AJ/P21-1908

Town and Country Planning Act 1990
Application for Non-Material Amendments to Full Planning Permission 16/02446/F
Dorchester Phase 9A and 9B, Land South West of Camp Road, Heyford Park, Upper
Heyford, Bicester, Oxfordshire, OX25 5HD

Please find enclosed an application submitted on behalf of our client, Elgin Investments LLP, for Non-Material Amendments (NMA) to full planning permission 16/02446/F with regards to Dorchester Phase 9A and 9B of the development at Land South West of Camp Road, Heyford Park, Upper Heyford, OX25 5HD.

This application seeks to amend Condition 2 of the full planning permission (ref: 16/02446/F) in so far as the plans and particulars of the permission for Dorchester Phase 9A and 9B are to be amended by those drawings hereby submitted.

Drawing Title:  
**HOUSE TYPE DL2v2  
 GROUND & FIRST FLOOR PLANS**

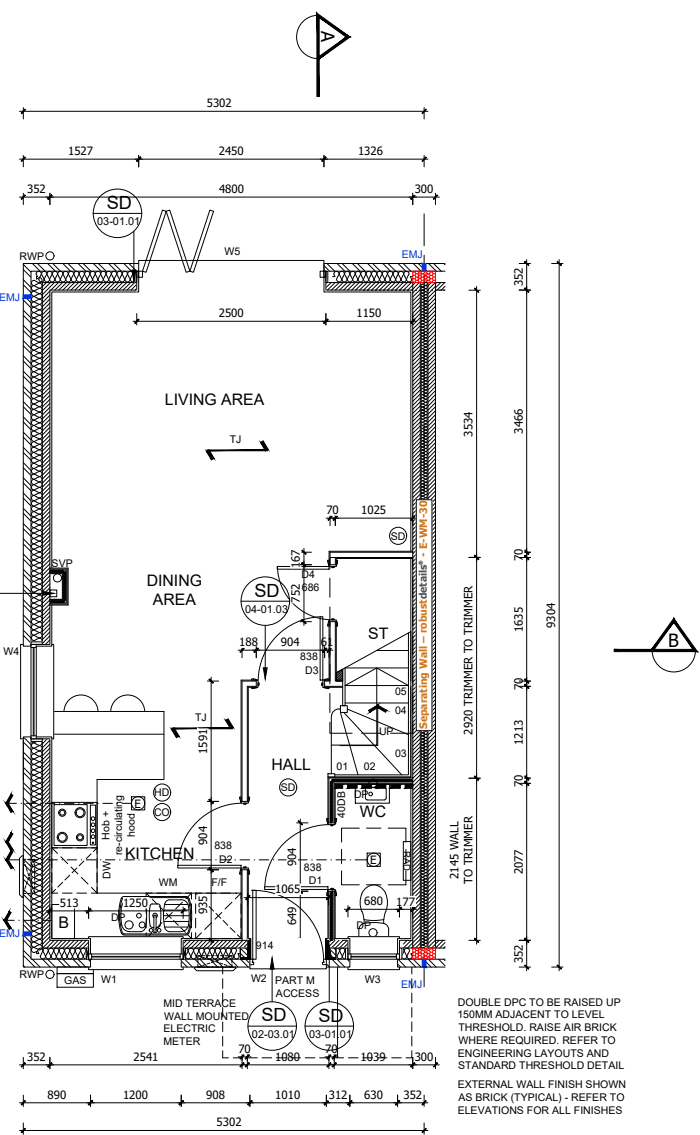
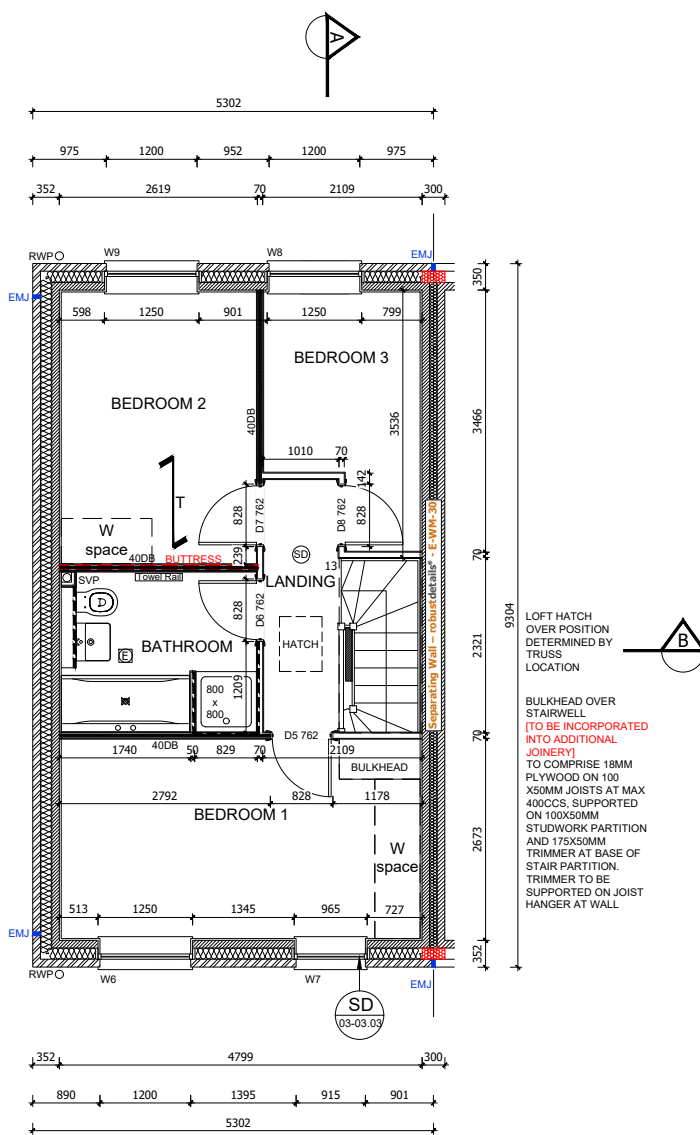
- DL2 design replaced with the DL2v2 (removal of en-suite) and elevational treatments updated according to site location. Key elevations with stone detailing.

Drawing Title: HOUSE TYPE AF3 ELEVATIONS [RENDER]

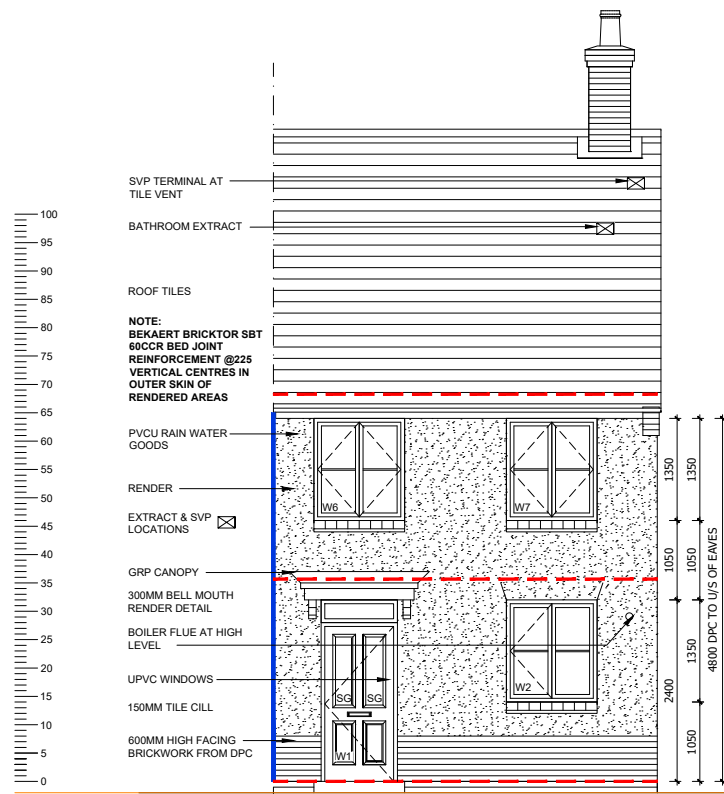
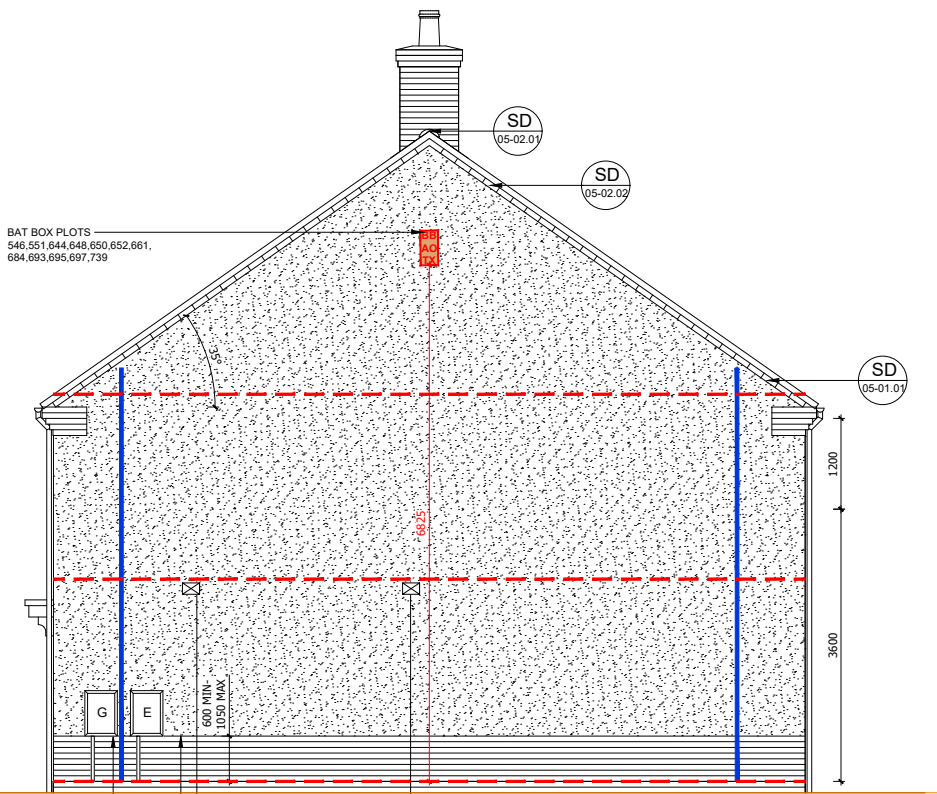
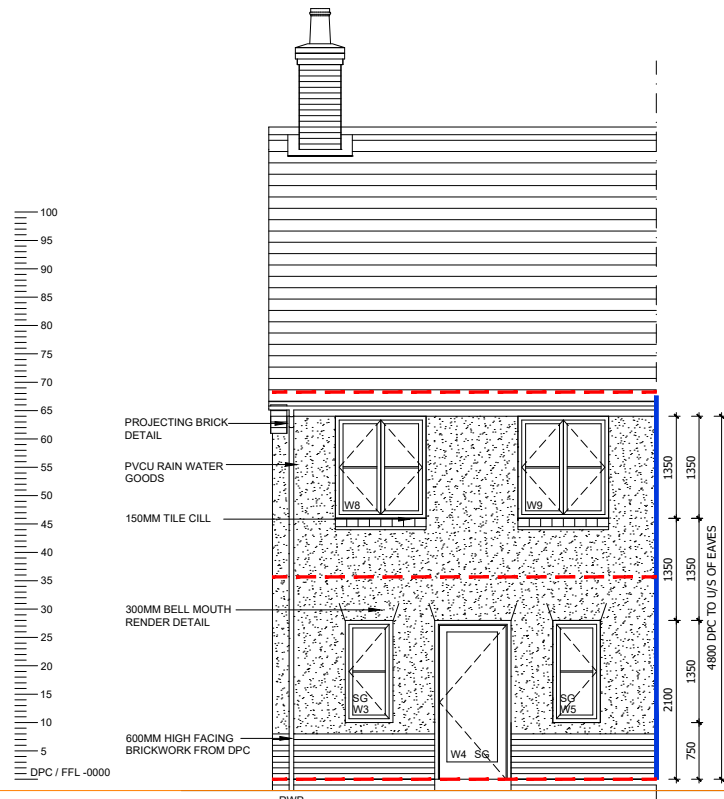
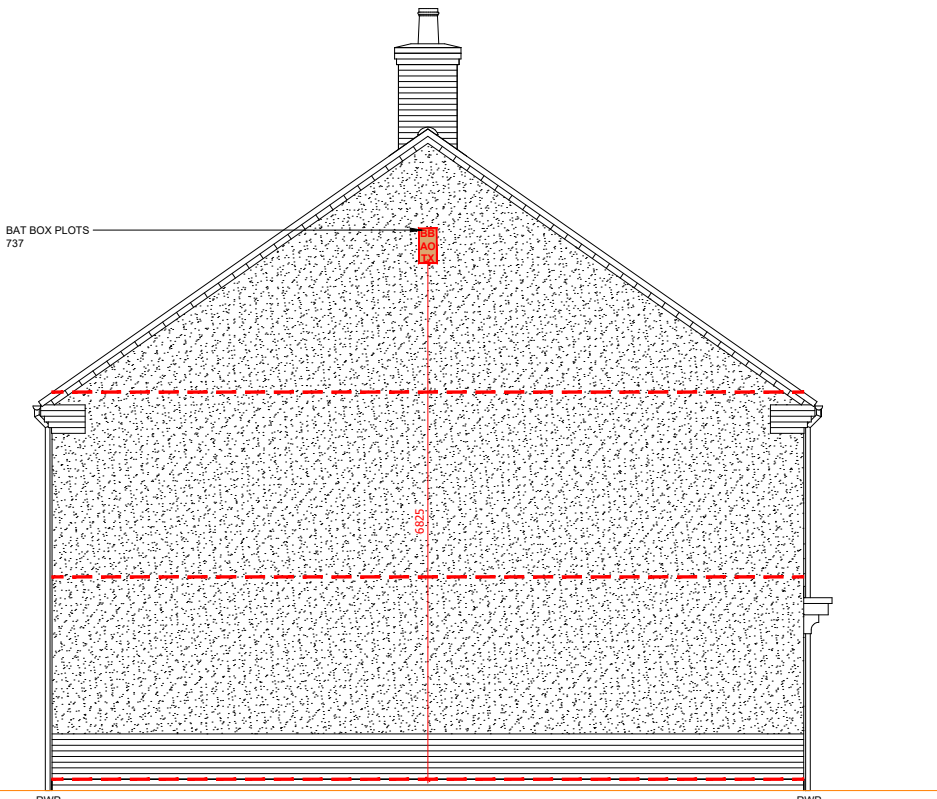
- AF3 units 546-551 changed to render. Previously 4 of the 6 were in brick. Windows to the side have also been removed to deal with the notional boundary Part B issue that was raised by Building Control following the grant of planning permission.
